5 February 2014

Our Ref : 2014/023873-02

**RE: Section 75W request to modify the approved Project Application
MP11_0091 MOD 1 for Blocks 6 and 7 at Central Park, Chippendale (former
Carlton United Brewery site)**

1 LONG SECTION & REAR WEST ELEVATION
1:100

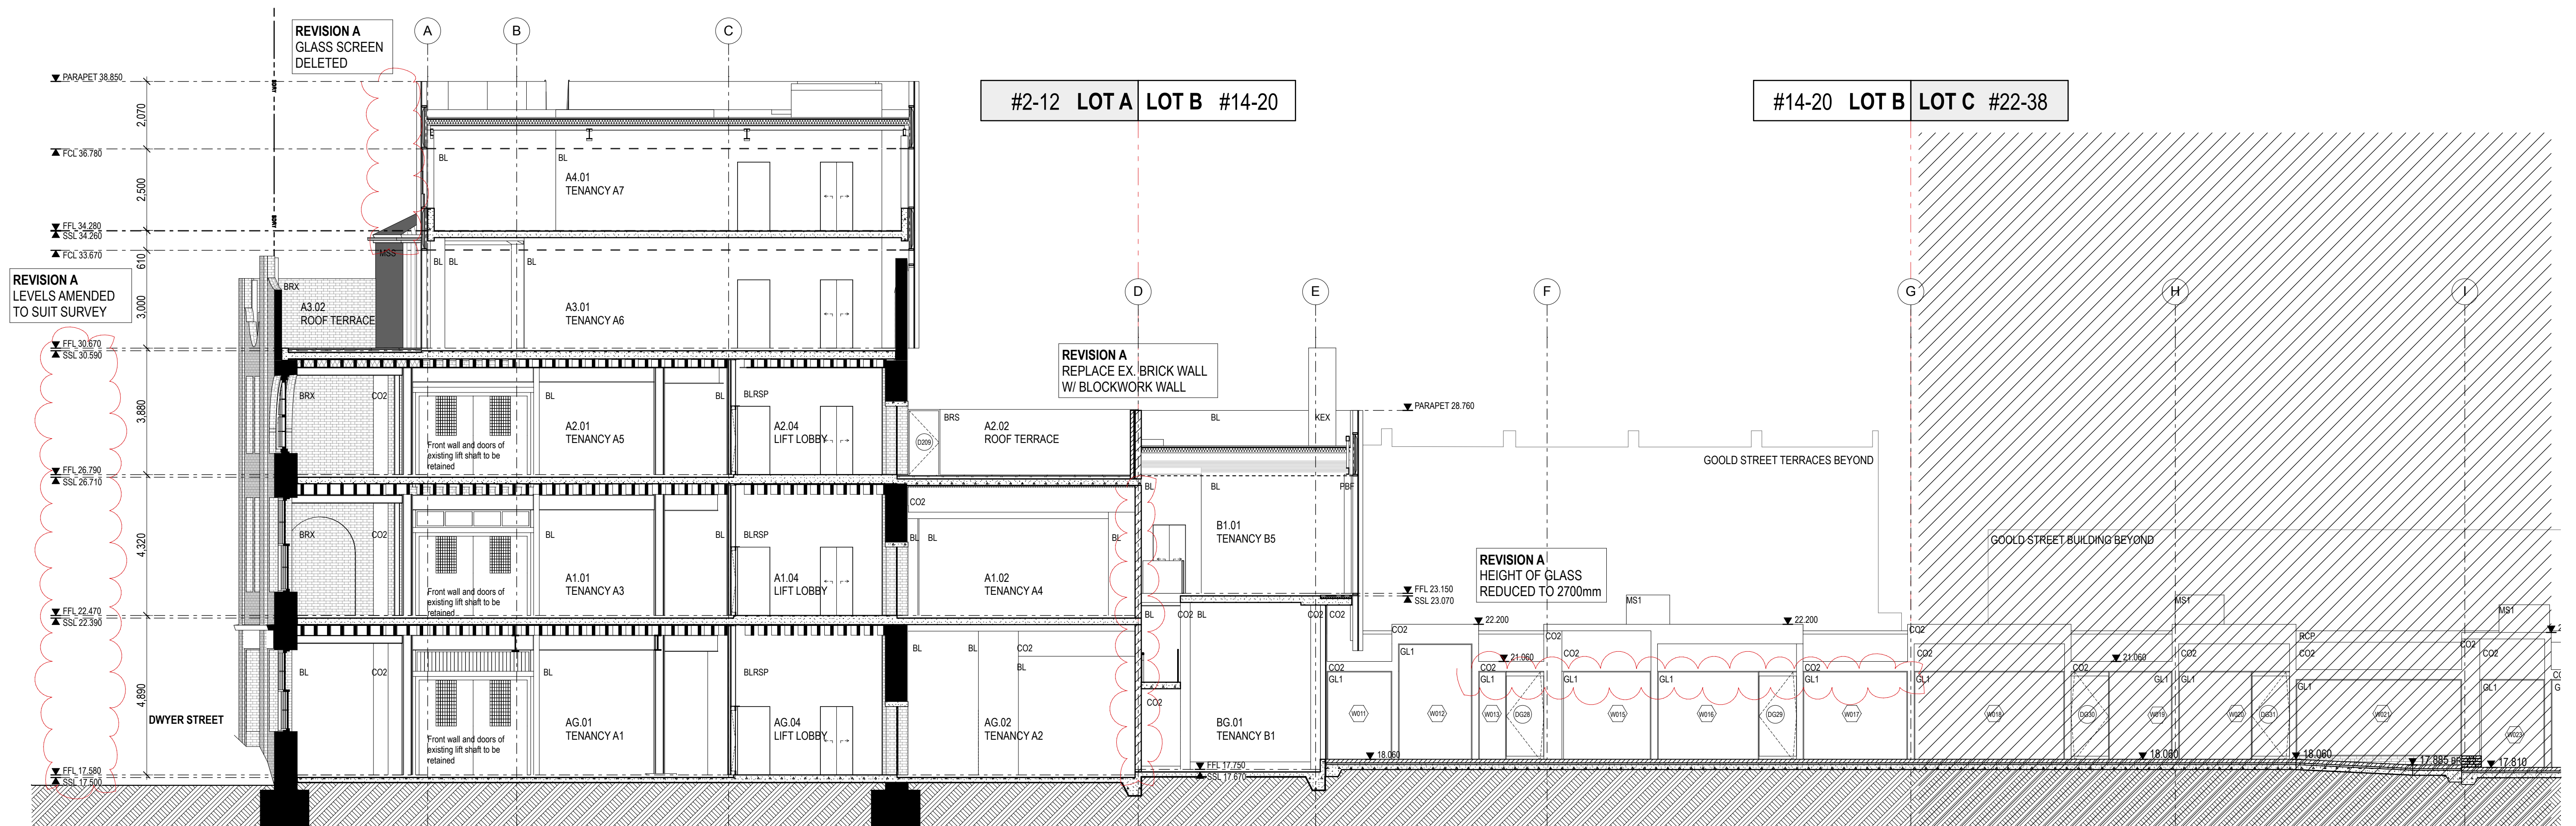
However, concern is raised regarding the proposed reduction in height of glazing on the western façade of the rear laneway buildings to 2700mm. The proposed uniform height of the glazed shopfronts and increased height of bulkheads lacks visual

interest, reduces vertical rhythm which interprets the built form of the adjacent terraces. This modification does not contribute to design quality of the buildings.

The City notes that the proponent has not submitted any detailed justification for the design modification. It is therefore the City's preference that the western façade of the rear laneway buildings be retained as originally approved.
